GOVERNMENT ARCHITECT NEW SOUTH WALES

23 May 2023

PROJECT: new Sydney Fish Market – SSD 8925
RE: Design Integrity Panel Meeting 15 – 17 May 2023

DRAWING NO.	REVISION
SP-LA-SK-00026	2

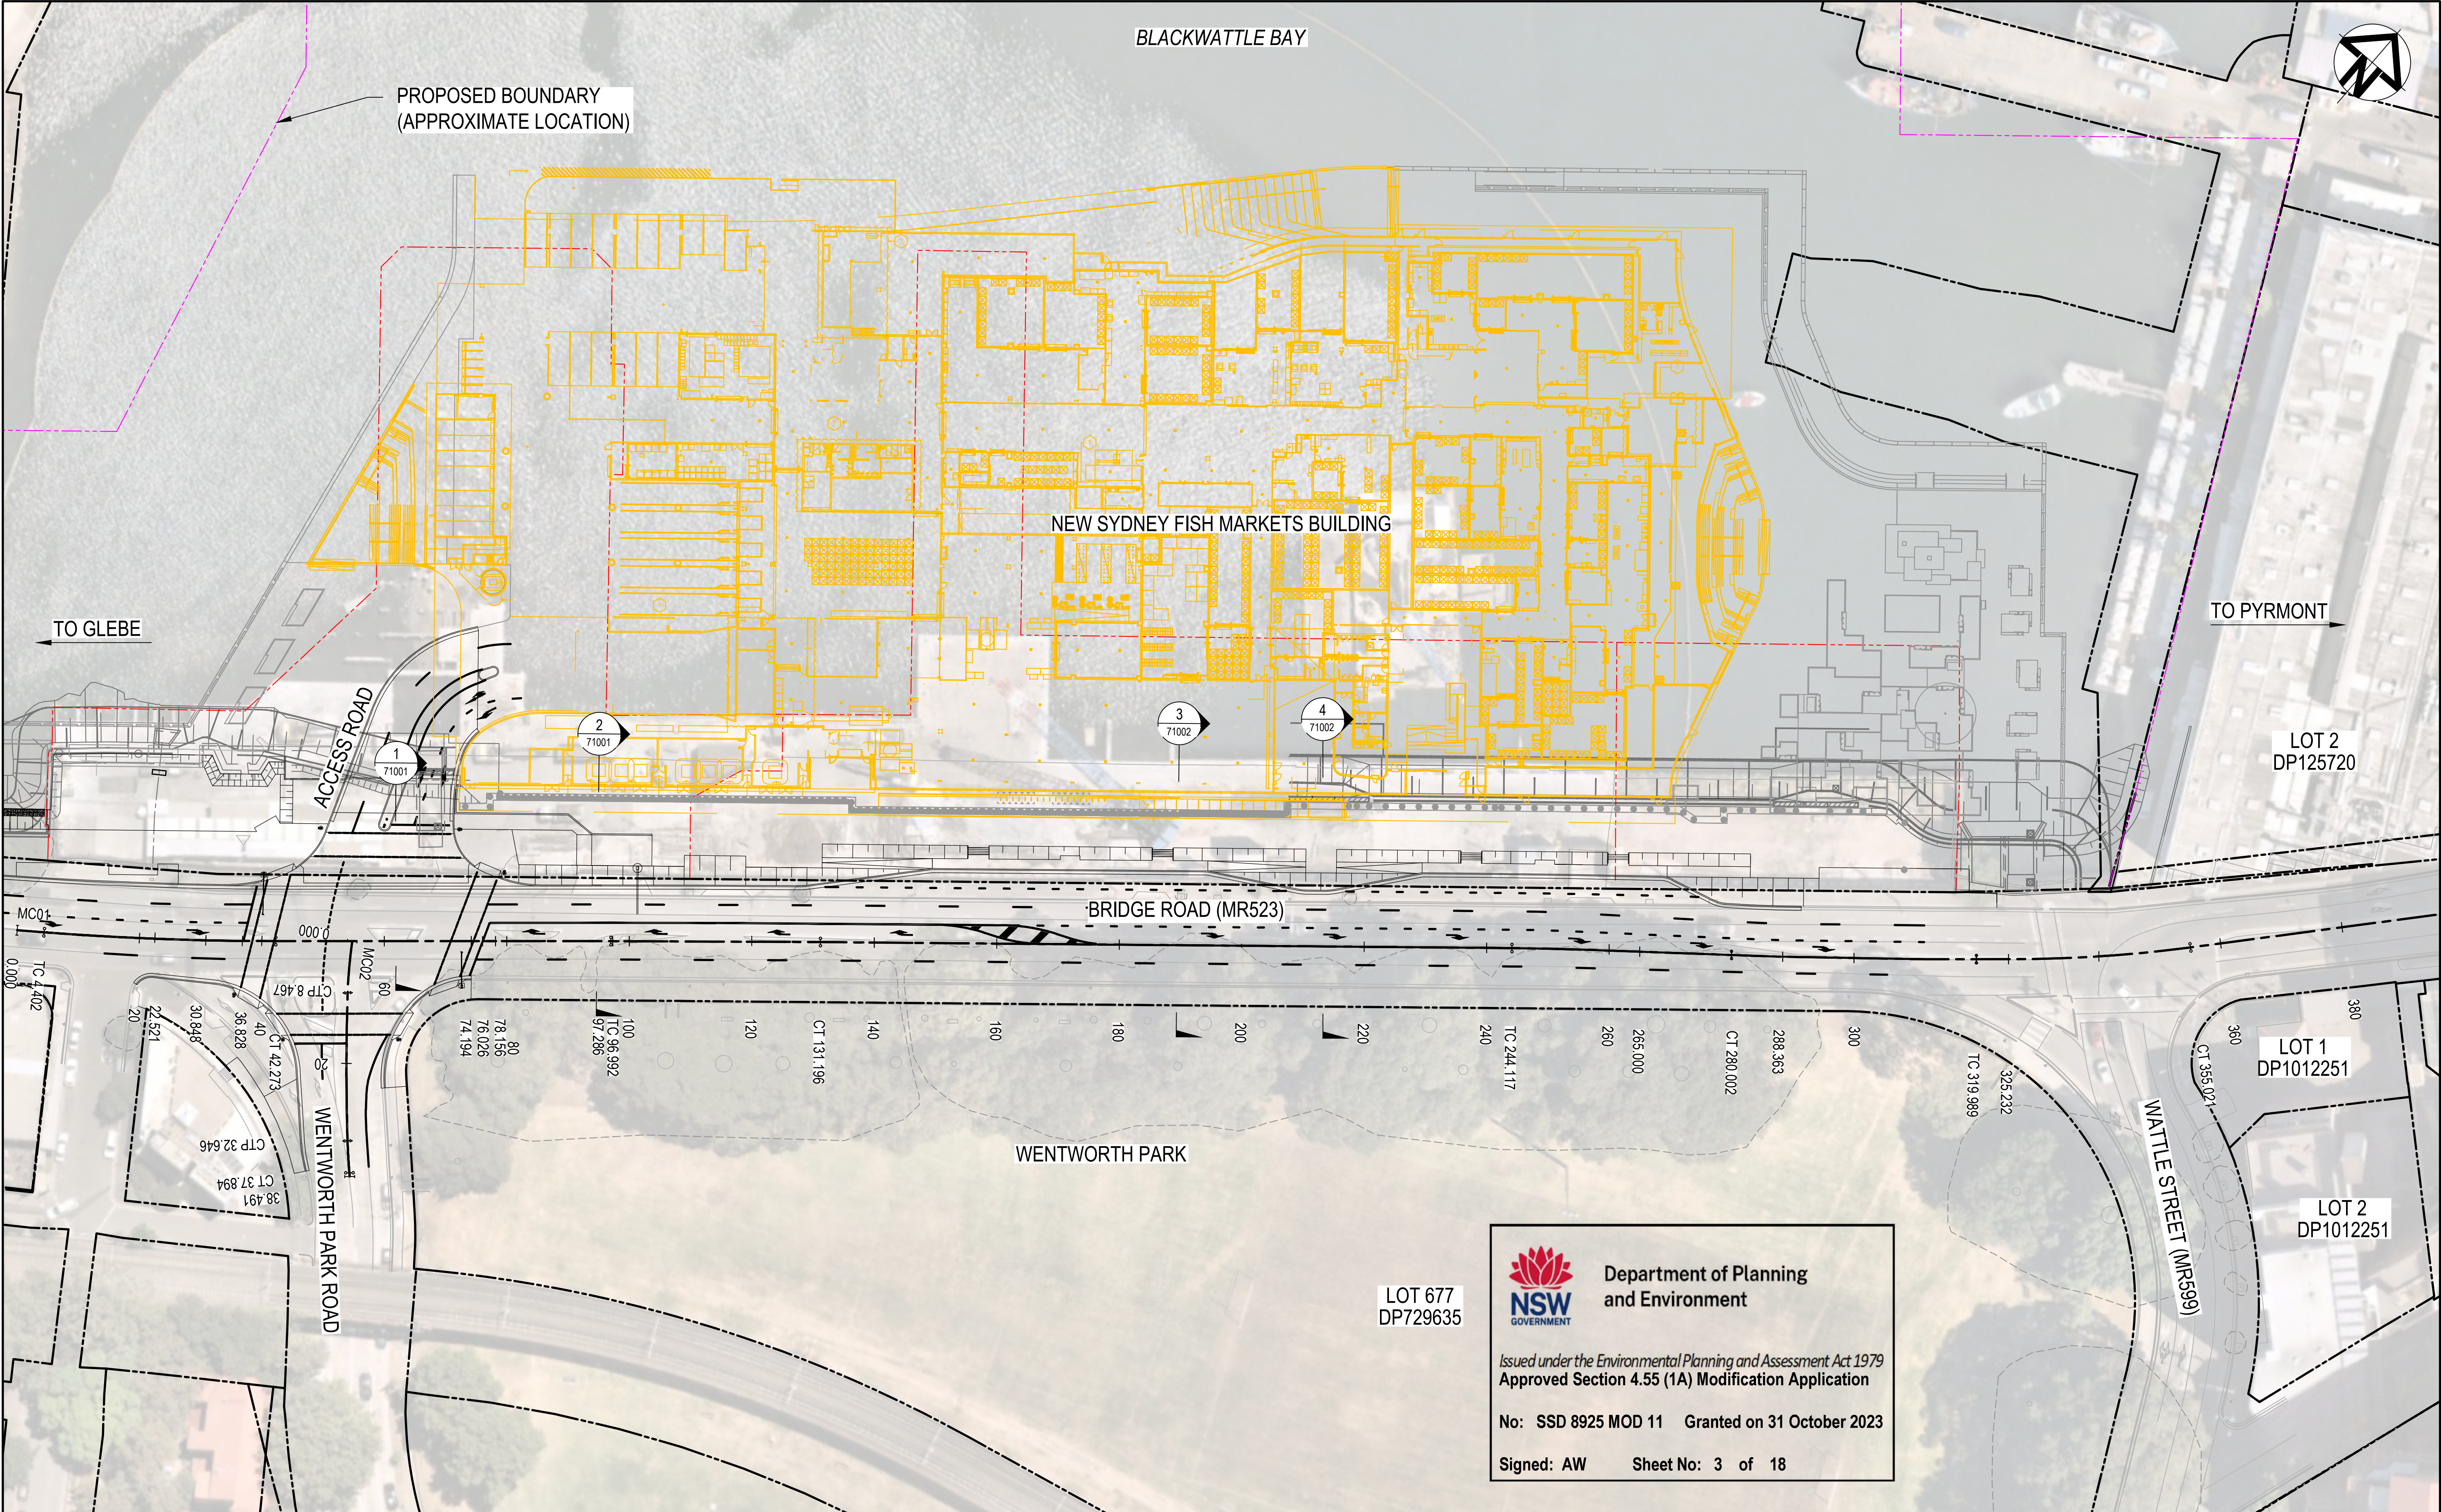
1. The safety audit should be reviewed and updated in response to the alternative scheme proposed. The audit should encompass the western intersection of the Bridge Road promenade as part of the finalization of the masterplan.
2. The width of the stairs from the lower footpath to the main promenade should be maximised, but not so wide that it would require the introduction of a central handrail.
